Our Ref: BR/27/20/DOC

Approval of details reserved by condition imposed under ref BR/63/19/PL relating to Condition Nos 3 - dustbin storage, 5 - renewable energy, 7 - material & finishes, 10 - Construction Management Plan, 13 - cycle parking spaces, 15 - visibility splays and 16 - pedestrian visibility splays

15-17 Kew Gardens Bognor Regis PO21 5RD

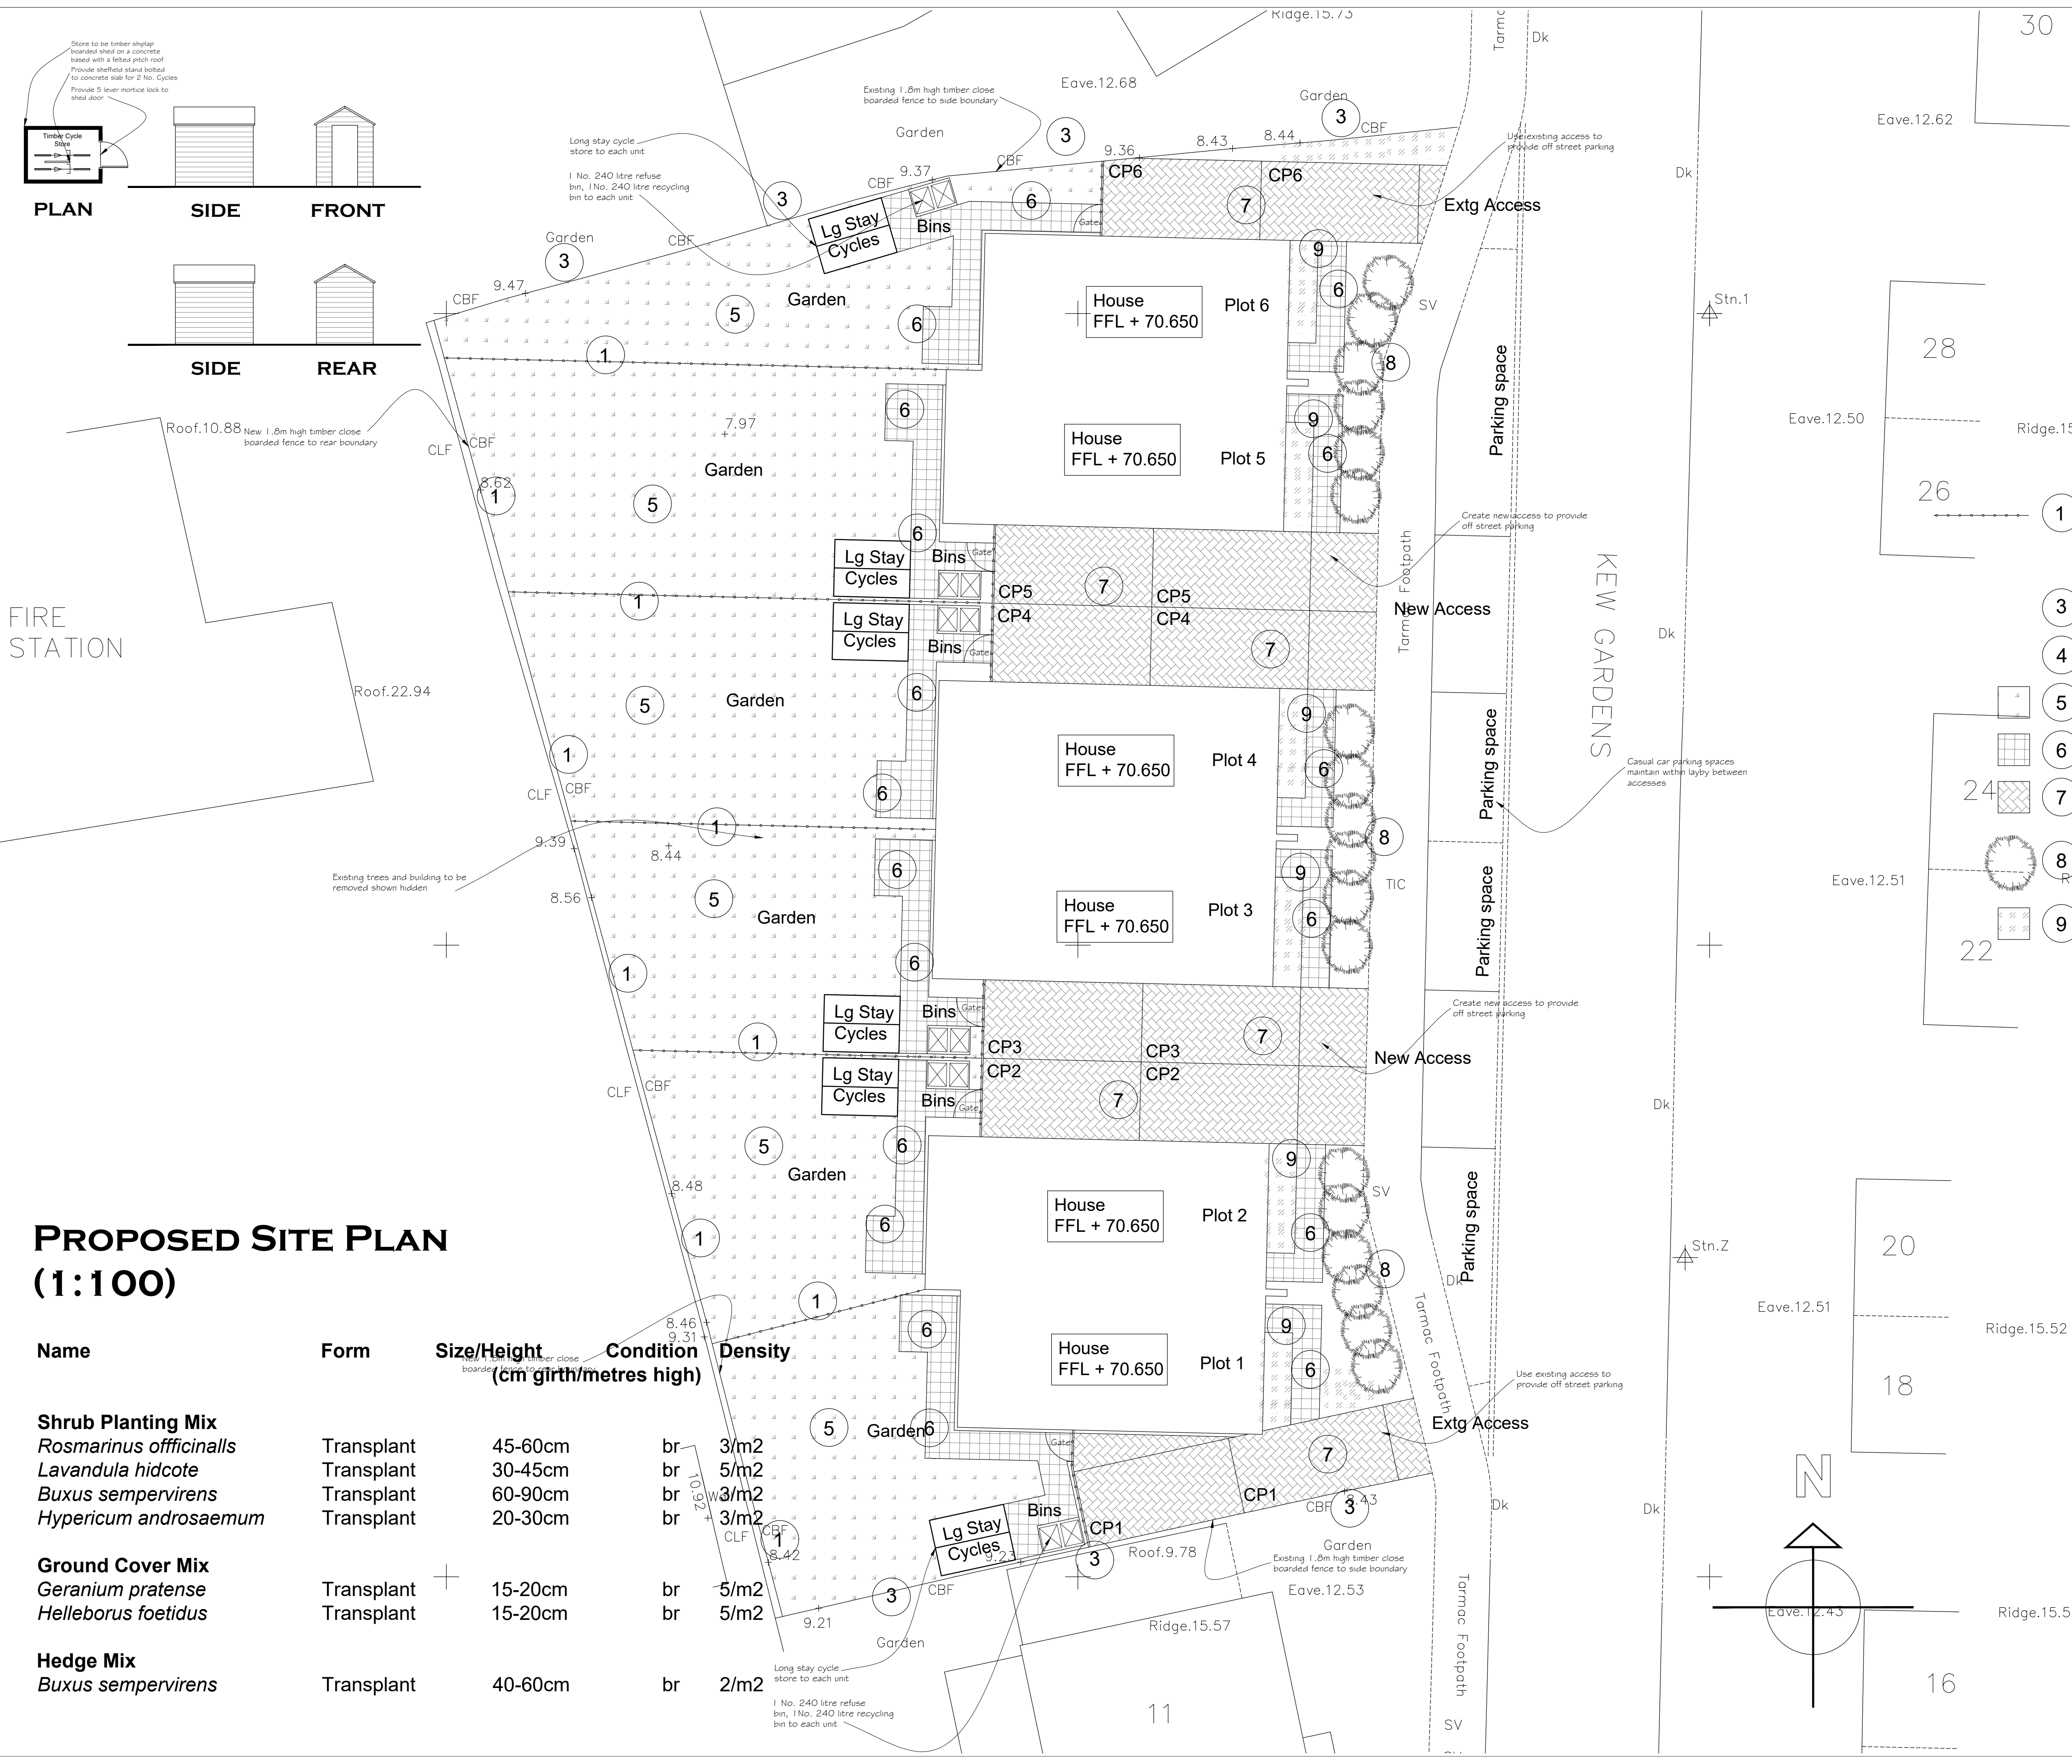
The submitted details in respect of the fences, the proposed bin store hedging and surfaces as shown on Drawing No.13 Rev A dated 06/04/20 are considered to be appropriate and satisfy the requirements of the condition.

The condition is therefore fully discharged insofar as the submission of details relates and on the understanding that bin storage areas will be permanently retained.
